Planning Officer: Mr D Easton

Planning Application Ref: Y/127/21/RES

Location: Land at Bilsham Road, Yapton

Description of works: Approval of reserved matters (appearance, landscaping, layout and scale) following the grant of Y/91/17/OUT for 250 No dwellings with associated parking, road/footway/cycleway provision, open space, landscaping, surface water attenuation & ancillary works (resubmission following Y/152/20/RES). this site is not CIL Liable as in Yapton Strategic Site

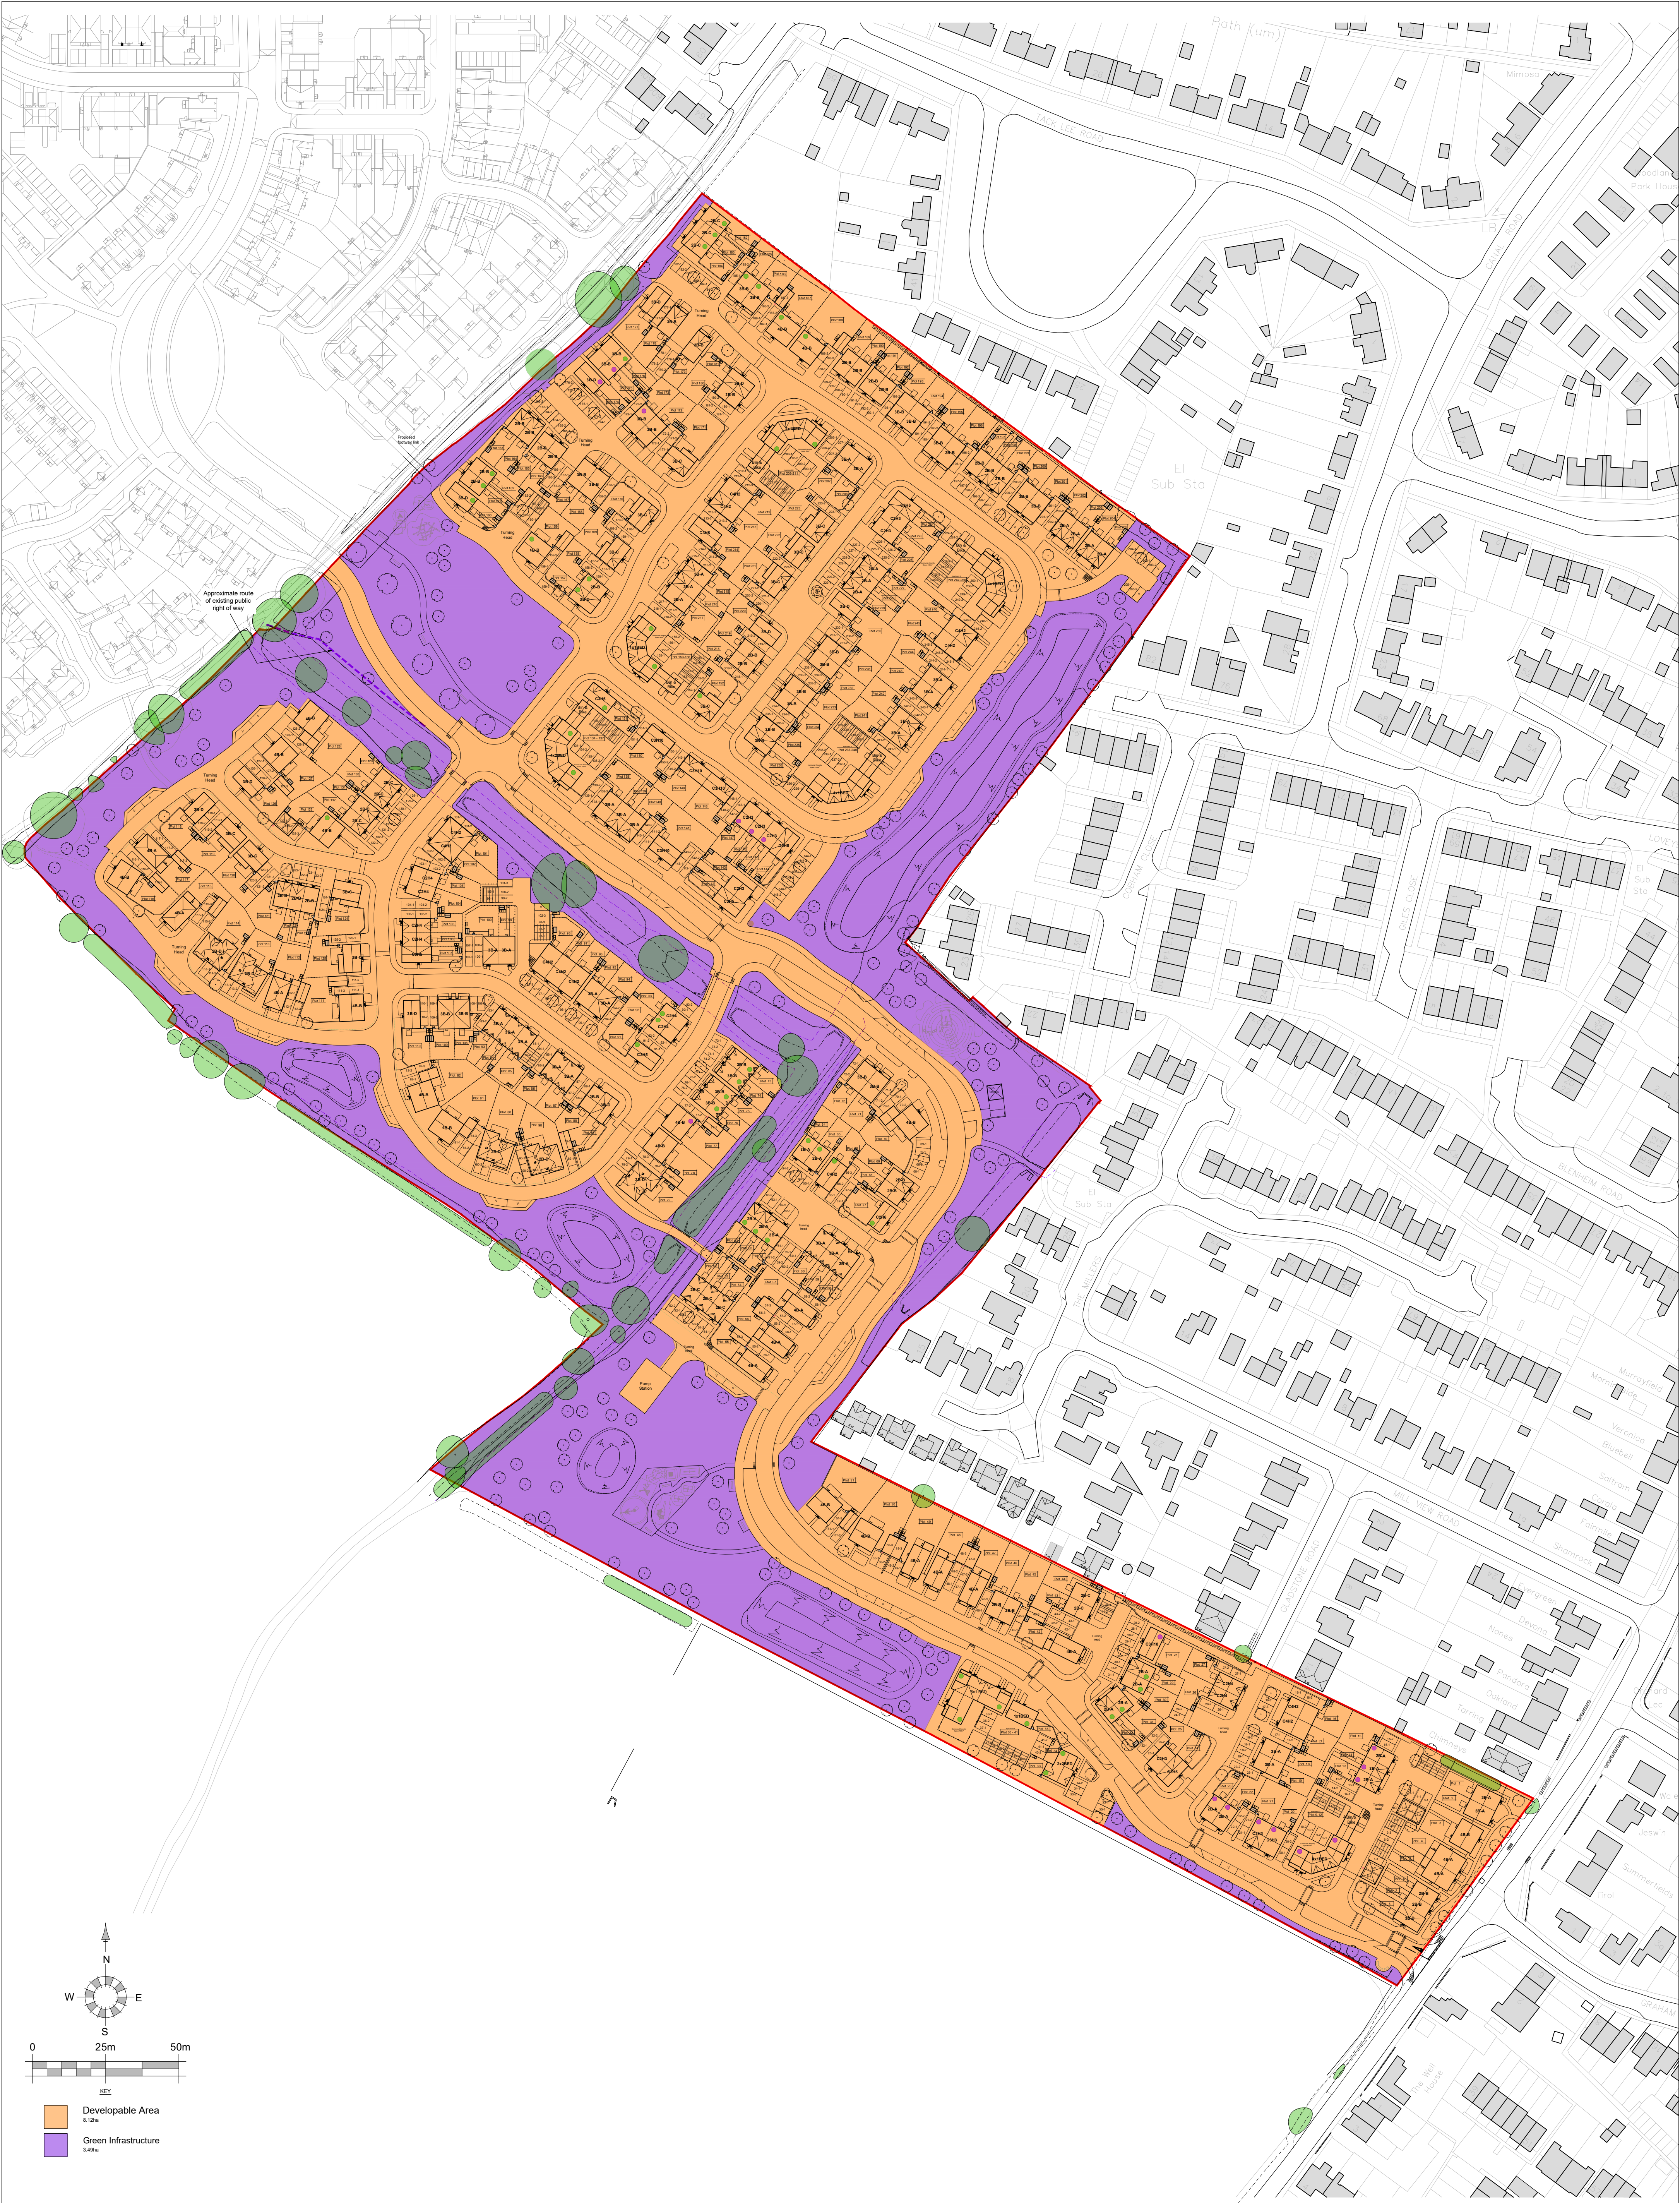
- I must await the necessary arboricultural reports and plans before commenting in detail on layout proposals, but it is already clear from Proposed Site Layout Full Site (dwg. 19284.P201) that a large, veteran oak (N of plots 93-95) will be heavily impacted by footway creation, drain reconstruction or enhancement and change of land use (to rear garden) – all within the nominal RPA. Such a tree ought to be considered for a 15metre RPA to ensure it remains viable for long-term retention and retains high ecological value (avoiding risk mitigation pruning). This was highlighted at /OUT stage and discussed with the applicant's project arboriculturist at that time (2018), so it is disappointing not to see that being observed at this stage.
